Approval of details reserved by condition imposed under ref BN/121/19/PL relating to Condition Nos 3 - surface water drainage, 4 - Construction Management Plan, 5 - materials & finishes, 6 - hard & soft landscaping, 7 - drainage scheme, 8 - storage of waste and 13 - renewable energy.

Swallowfield Eastergate Lane Eastergate PO20 3SJ

Notification regarding the above application:

Revision:			
address Swallowfield, Eastergate Lane Eastergate, PO20 3SJ			
project Proposed construction of detached chalet bungalow			
title Proposed Surface Drainage			
scale 1:500 @A4	date May 2020	dwg no 2019.257DRA	revision

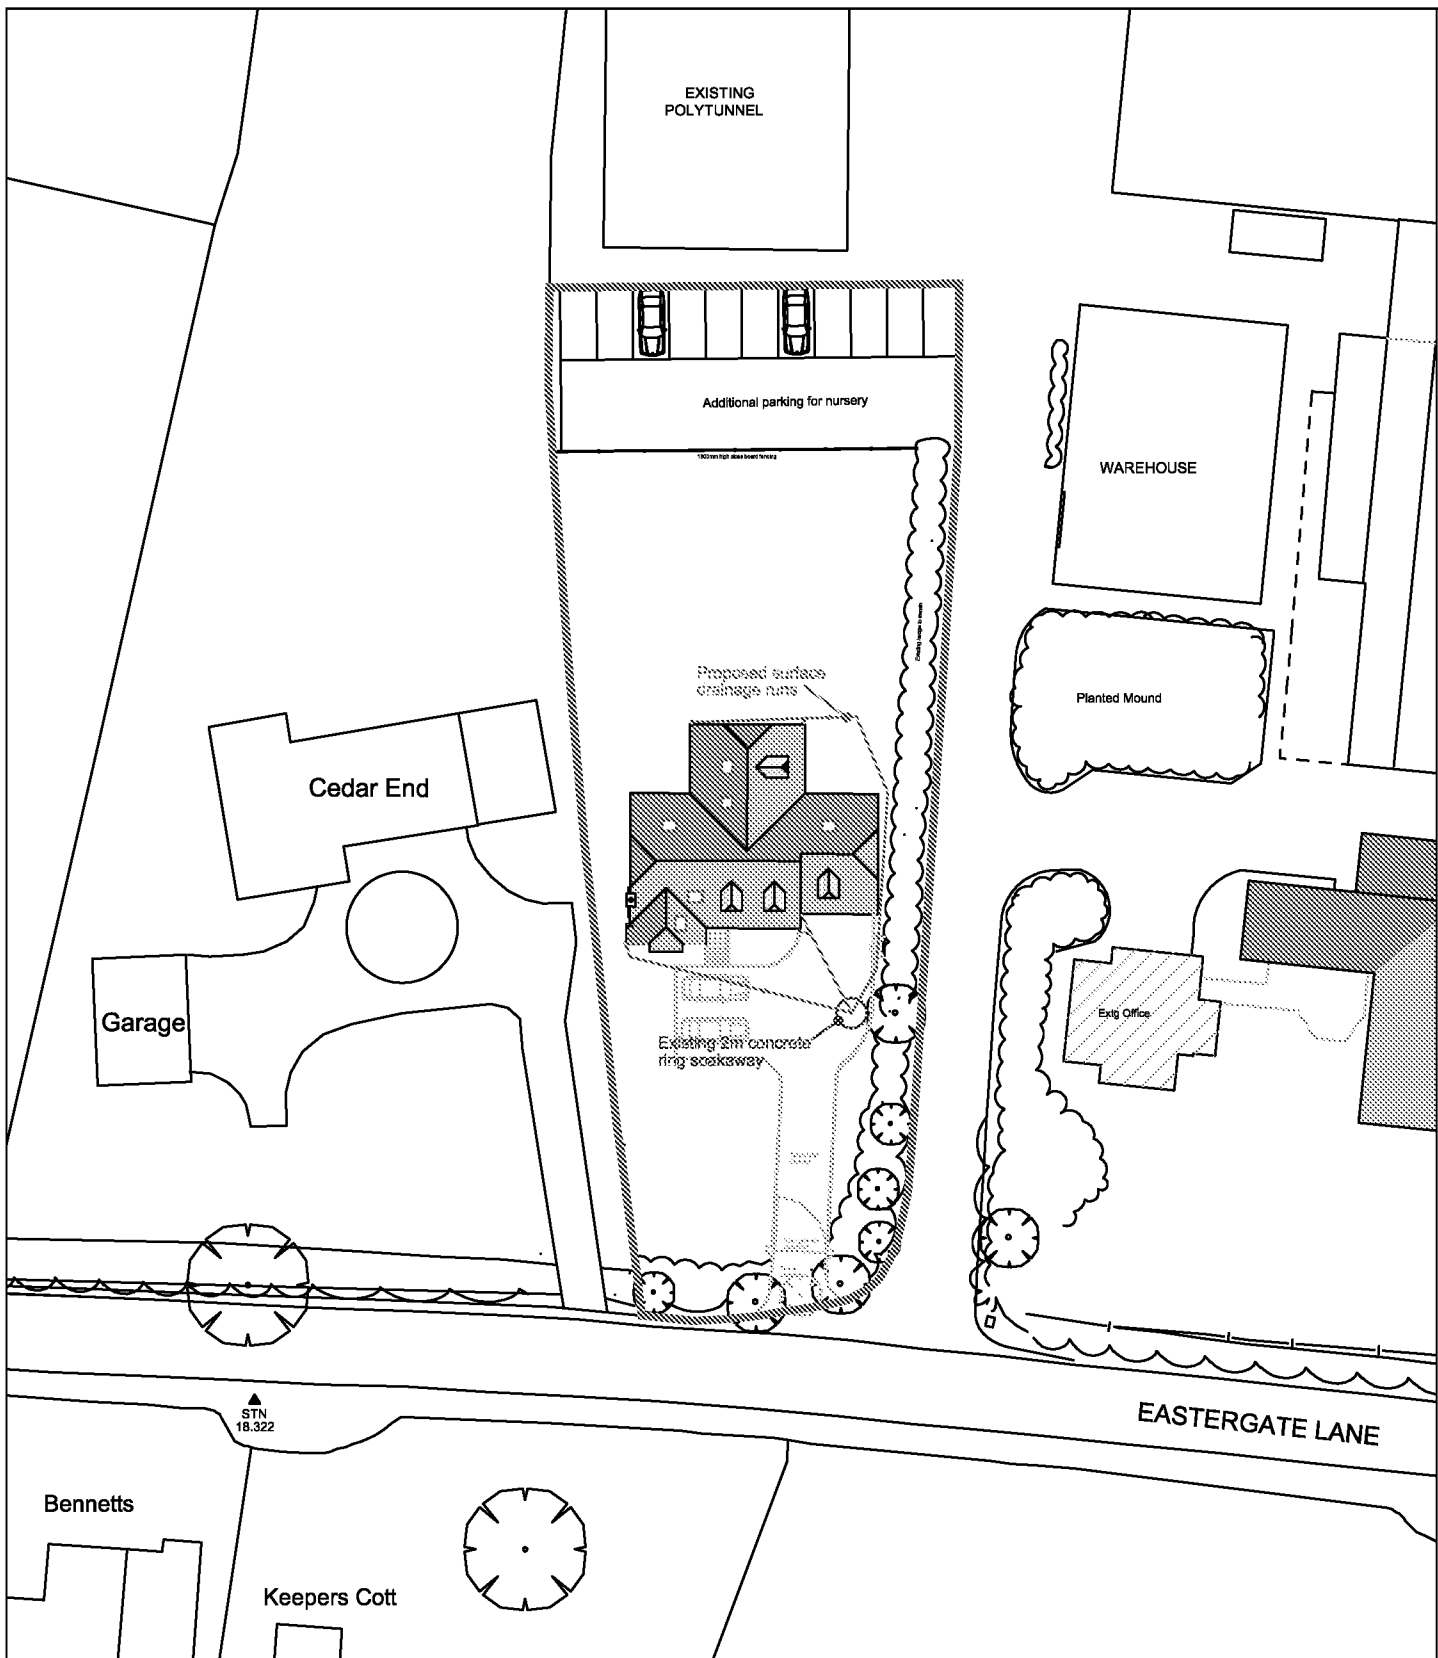
Arun District Council have decided to **REFUSE details reserved by condition for the following reasons:** Council Drainage Engineers objected to the discharge of this condition on the grounds that calculations will need to be provided to show that it meets our requirements, and a detailed drainage layout and

construction details will also be required. These calculations will rely upon winter infiltration testing (and groundwater monitoring) .
